CITY OF ALBUQUERQUE

May 30, 2012

Re: 101.7 The Team Office Building Conceptual Grading and Drainage Plan

Stamp date 5-23-12 (C12/D026)

Drawing file: FINAL / C12D026 GR CONCEPTUAL.pdf

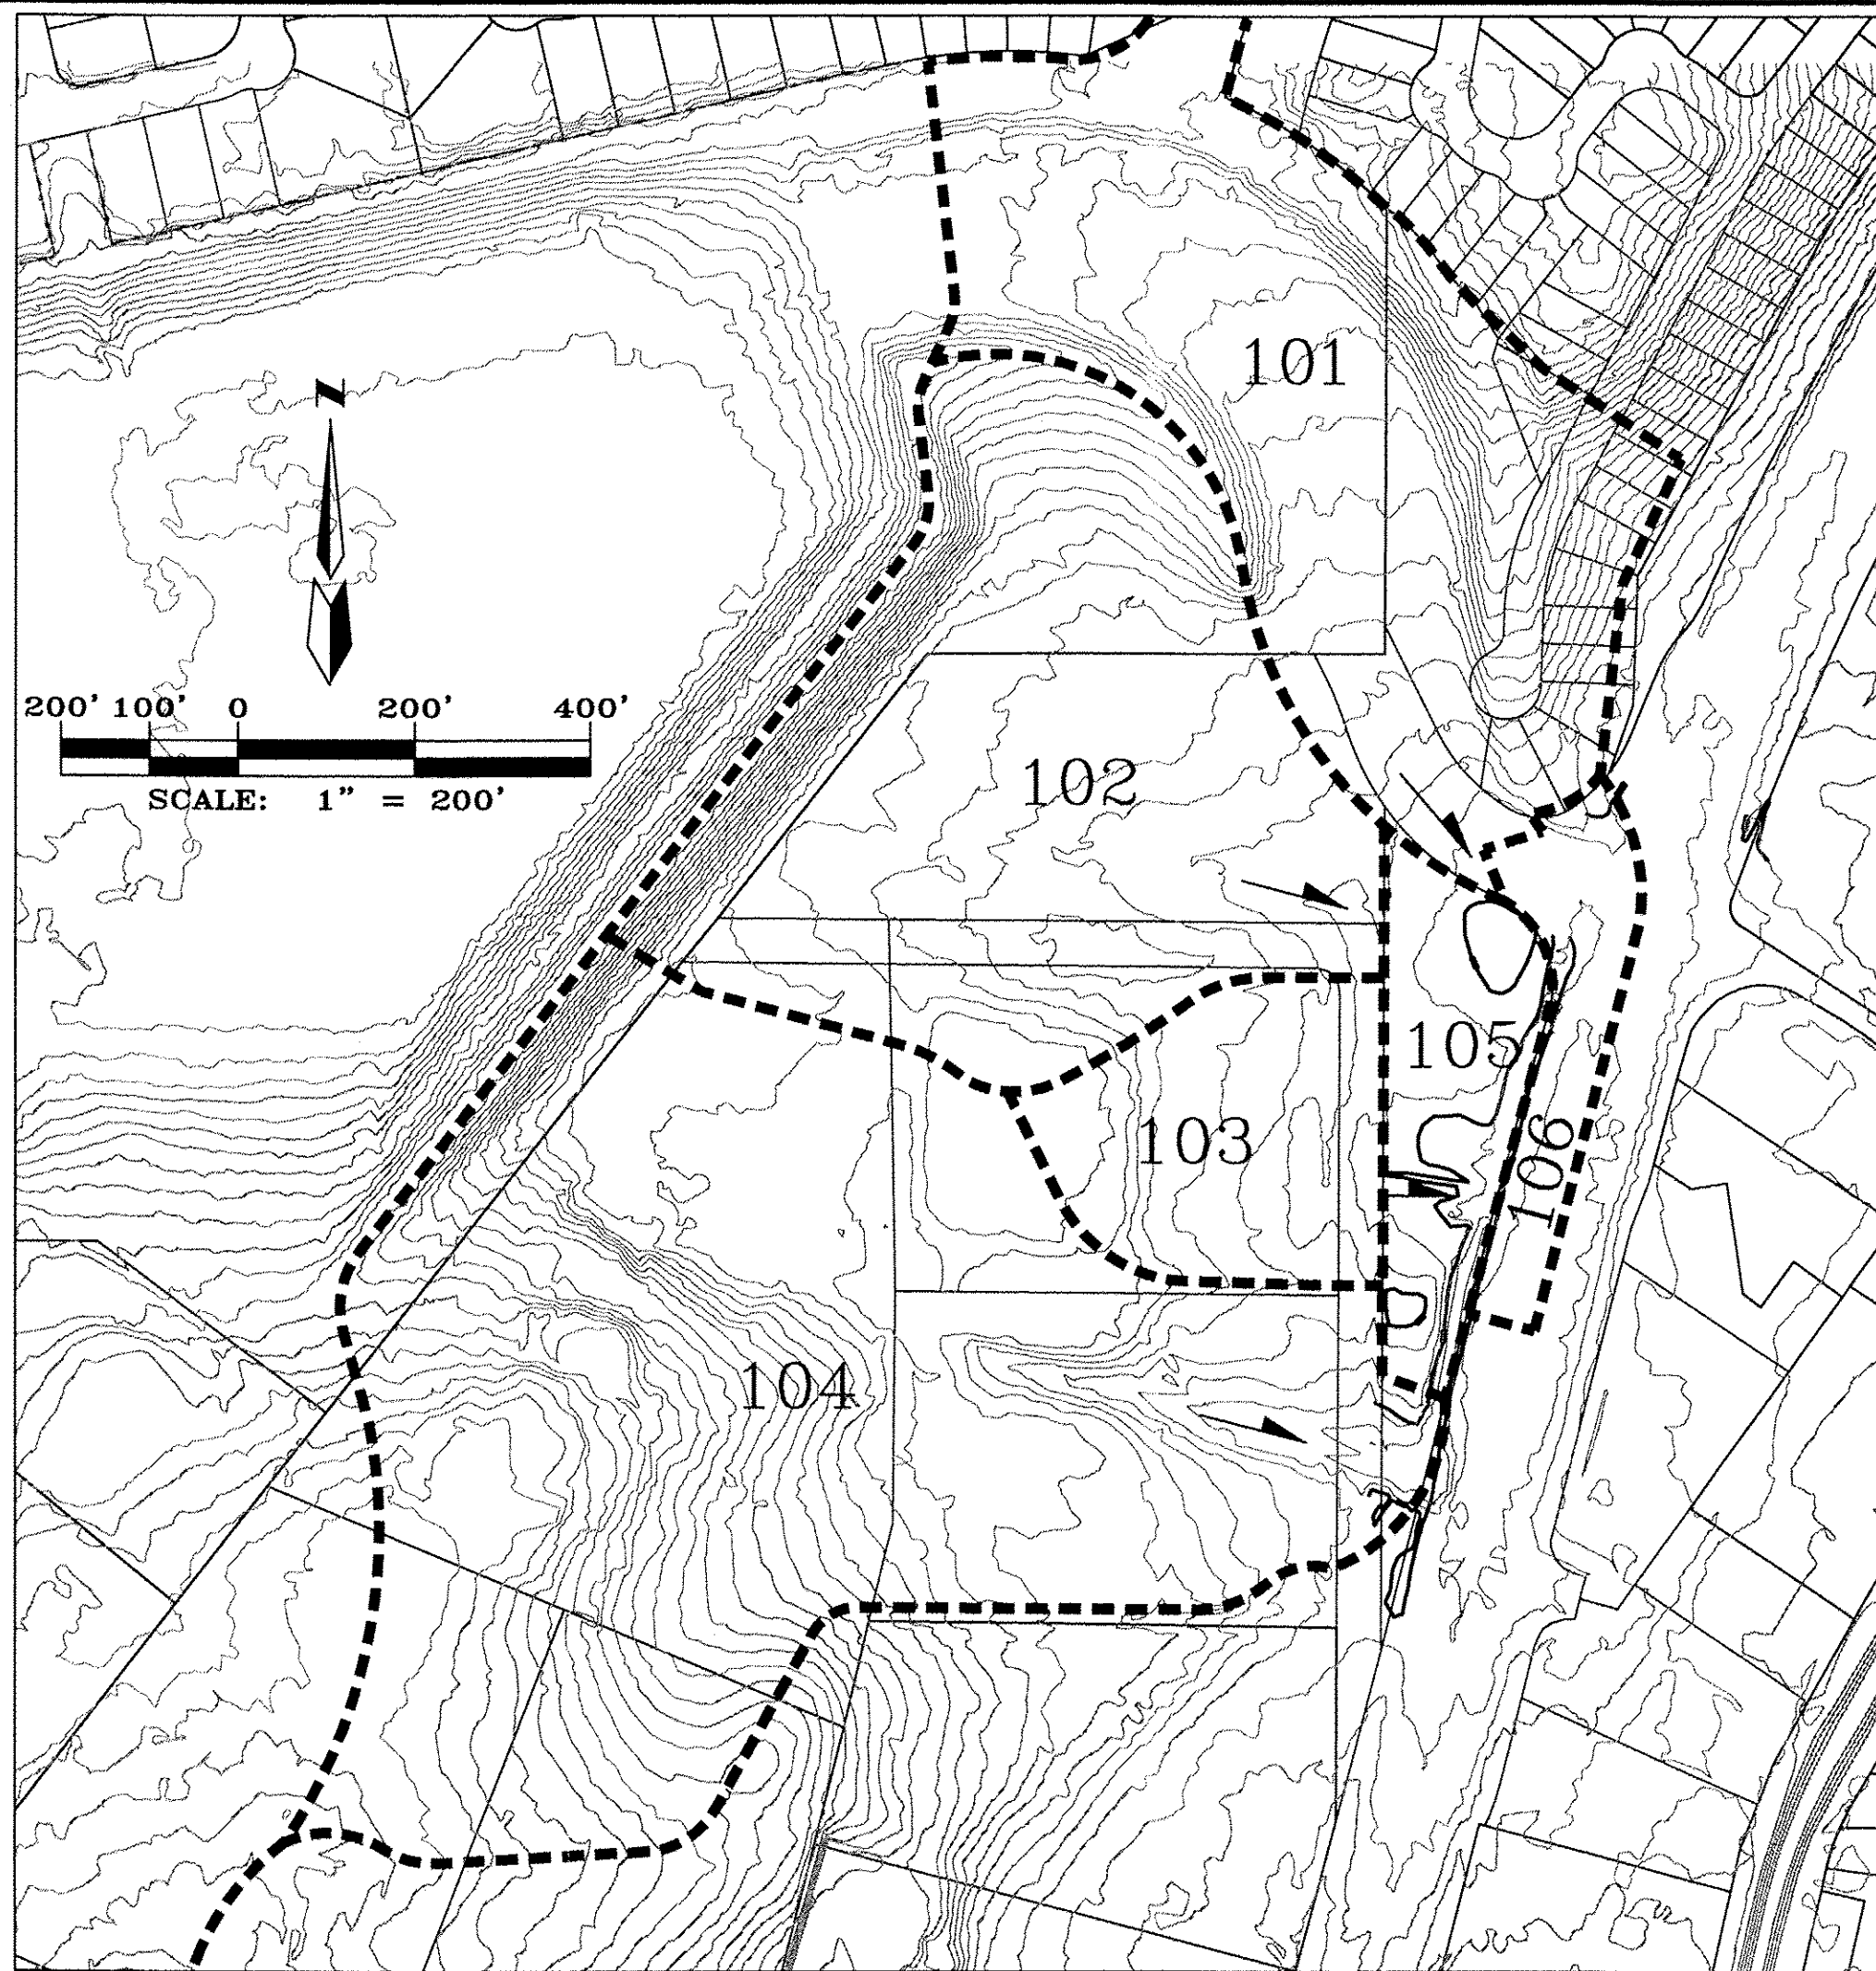
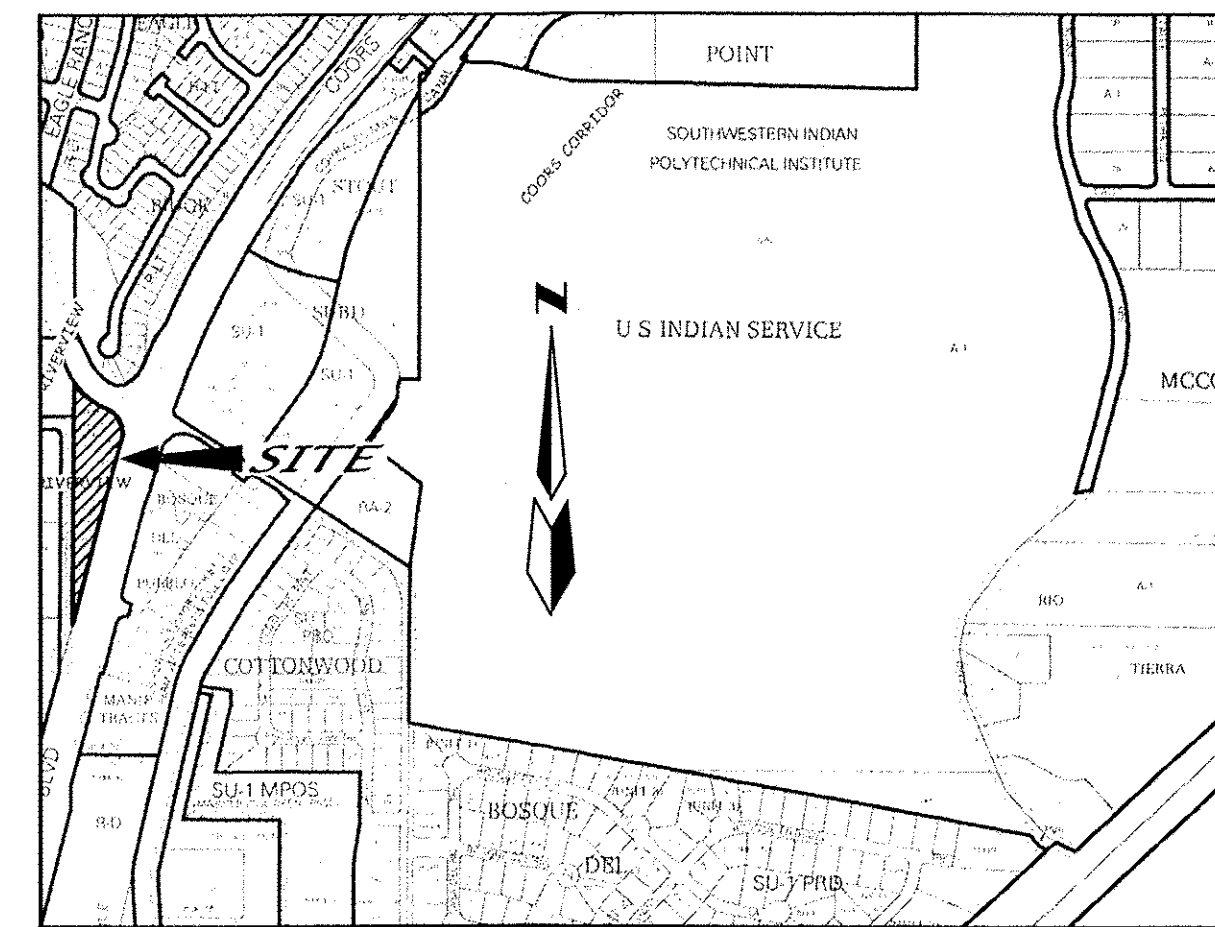
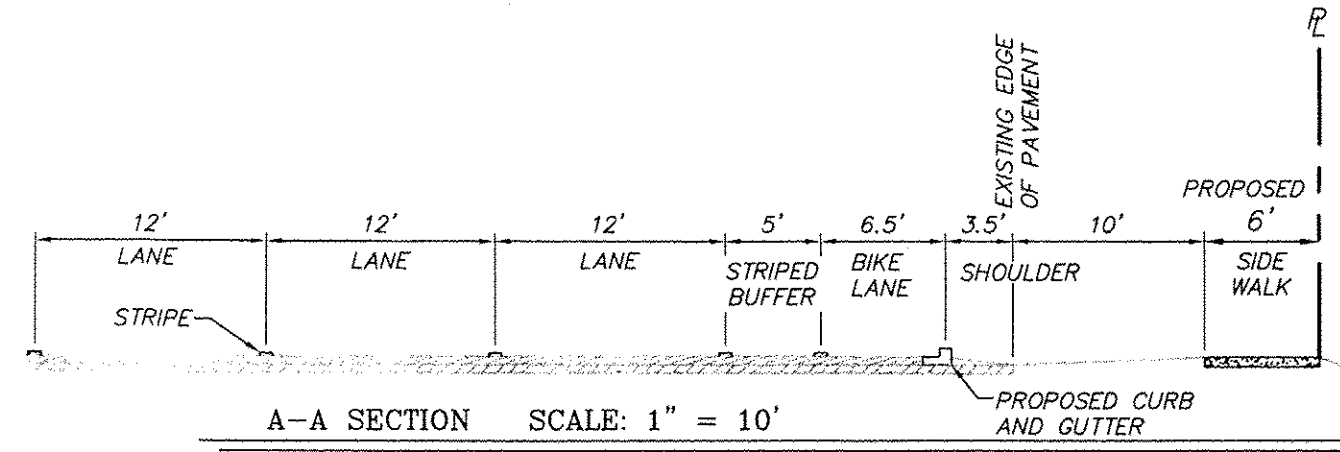
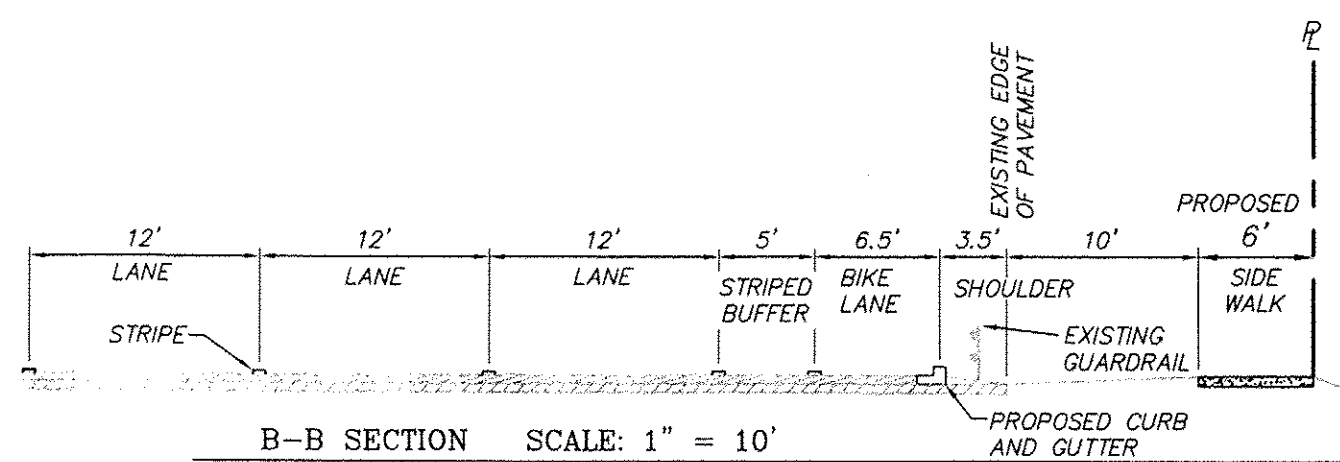
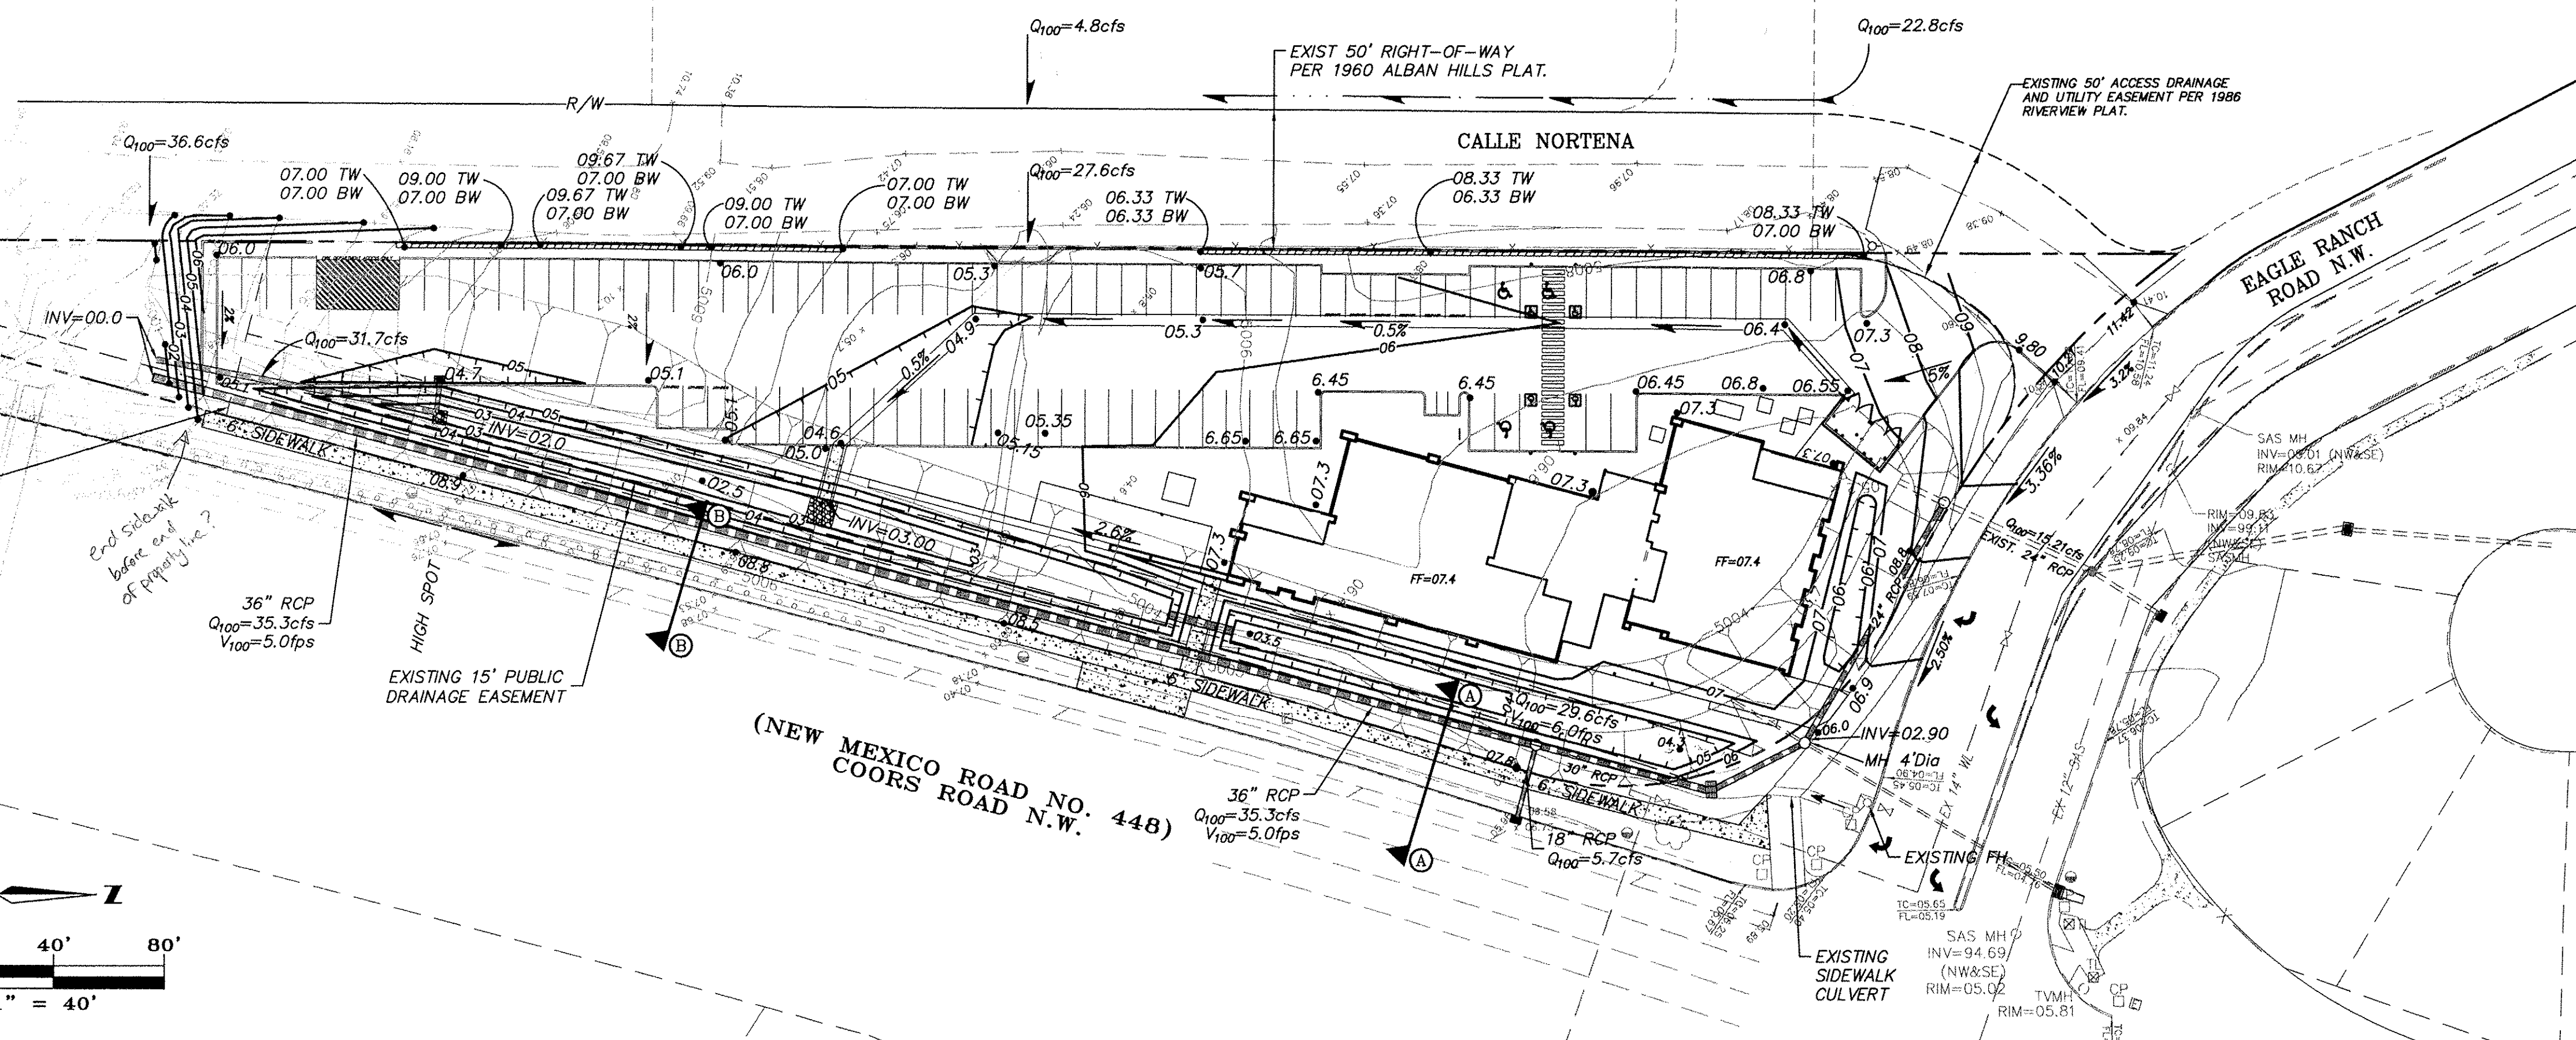
- The location of the proposed storm drain is to be approved by COA storm drain maintenance or NMDOT, depending on the final location. Written or e-mail approval is required prior to Building Permit or Work Order approval. The easement width may be widened.

- Another manhole may be required, since the length of proposed storm drain along Coors Blvd is 540 feet from manhole to daylight and the DPM requires a maximum of 450 feet. Access to this manhole will also be required.

- If the proposed location of the storm drain is onsite, a Public Storm Drain Easement and Agreement and Covenant will be required prior to Work Order. The Agreement and Covenant is for the area where the pond overlaps into the Public Drainage Easement. Storm Drain Maintenance does not maintain private ponds.
